Appeal Decision

Appeal Ref: APP/T2350/D/15/3017354

8, Chatburn Avenue, Clitheroe, Lancashire BB7 2AU

- The appeal is made under section 78 of the Town and Country Planning Act 1990 against a refusal to grant planning permission.
 - The appeal is made by Miss K Gibson against the decision of Ribble Valley Borough Council.
 - The application Ref 3/2014/0967, dated 16 October 2014, was refused by notice dated 23 January 2015.
 - The development proposed is two storey extension to the side, existing conservatory to be altered to form garden room with windows and slate roof. Existing garage altered to form playroom and utility.
-

PROPOSED PLANS AND ELEVATIONS

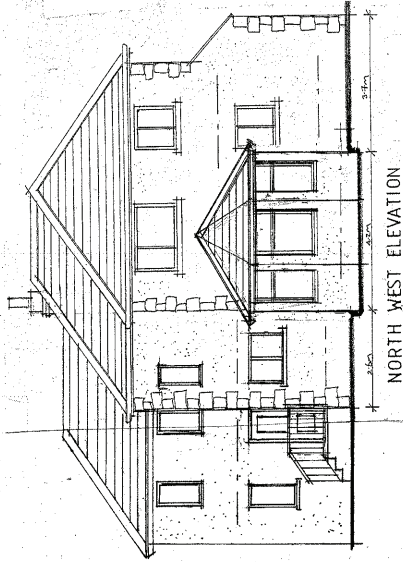
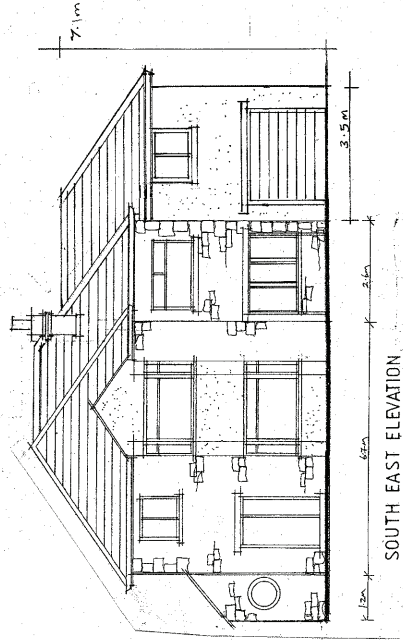
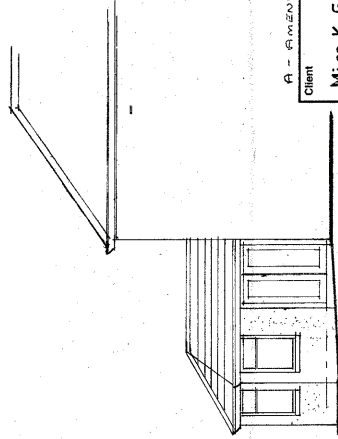
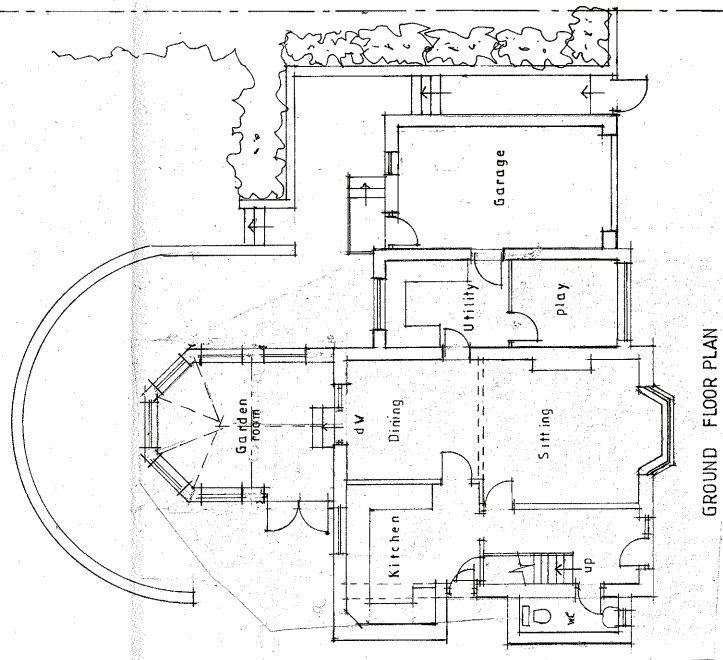
4. The existing property is an extended, detached, two-storey dwelling which has a hipped roof form and an attached conservatory to the rear. The proposed extension would be set back from the frontage of the existing property and down from the ridgeline. As such the mass of the resulting dwelling would be broken up and the extension would appear as a subservient addition to the building. The roof would be hipped, and the proportions of the windows would reflect those of the existing dwelling. No objections have been raised to the alterations to the conservatory or garage. Consequently, although it would result in a much larger dwelling than the original, the proposal would not, in my judgement, be harmful to the character and appearance of the host property.

5. However, there is a clear building line on the main part of Chatburn Avenue and properties are generally set back behind front gardens. This creates a sense of spaciousness. Although positioned side-on to this part of the road, No 8 currently reflects the prevailing pattern of development and maintains the building line. Consequently the space at the side of the property contributes positively to the character and appearance of the area.

6. The proposed development would extend considerably closer to the highway at the side of the site, substantially forward of the building line. As such it would erode the space at the side of the dwelling and harm the open character of the area. The effect of this would be exacerbated by the elevated position of the building, and the presence of the smaller scale bungalows adjacent to it, which would mean that the development would be dominant in views from the north-west. As such it would have a significant detrimental impact on the street scene and the character and appearance of the area.
